From: Michael Eastham
Sent: 03 May 2018 15:06
To: Planning.Responses
Subject: FW: Planning Consultation on: LU/88/18/DOC

APPLICATION LU/88/18/DOC
NO:

Site Address: Land North of Toddington Lane Littlehampton BN17 7PP

Description of Works: Approval of details reserved by conditions 10, 11, 12 & 13 imposed on planning permission LU/47/11 relating to drainage

Figure 2.1: Typical Permeable Block Paving Construction

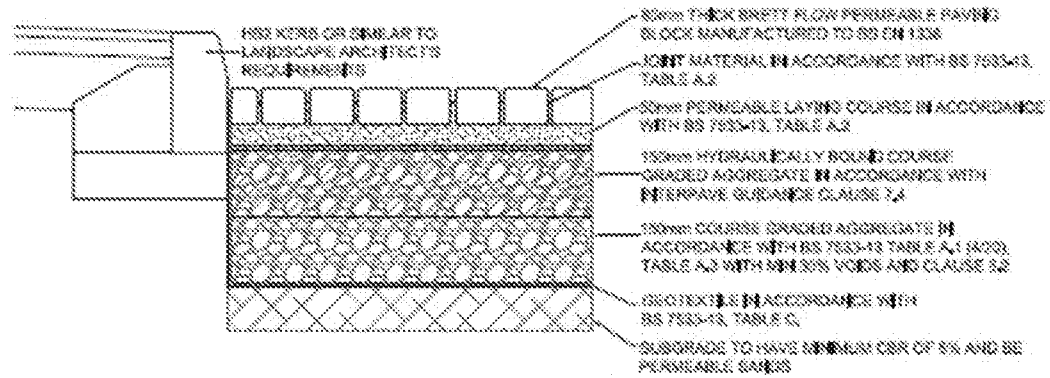
- permeable paving areas specified, detailing finished and formation levels, impermeable areas draining to these .

Figure 3.1 Existing Lagoon and Ditch (in green) to be filled in

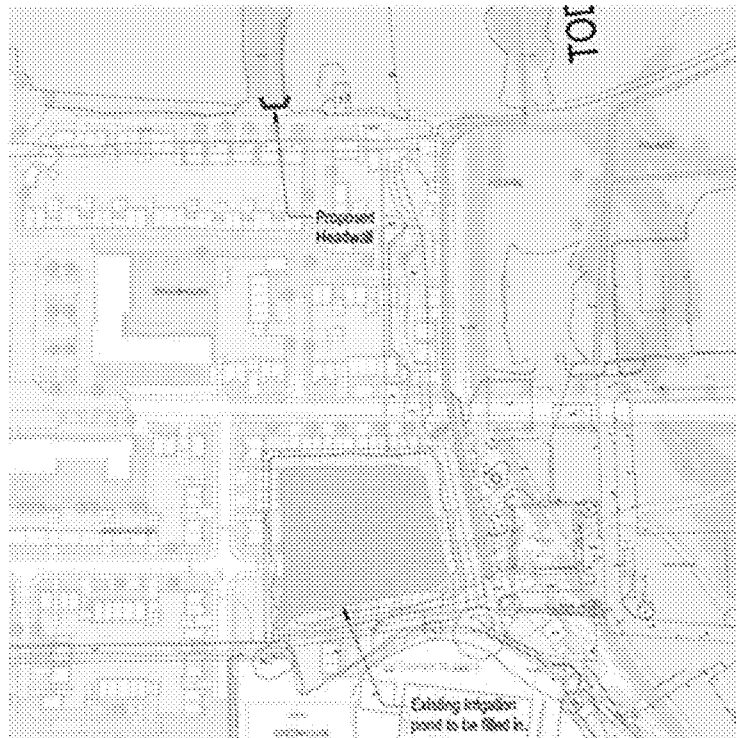
- I note that the Environment Agency has given consent to outfall to the black ditch.
- However, the proposal includes infilling an IDB ditch on site, consent will have to be applied for to do this from the Environment Agency.
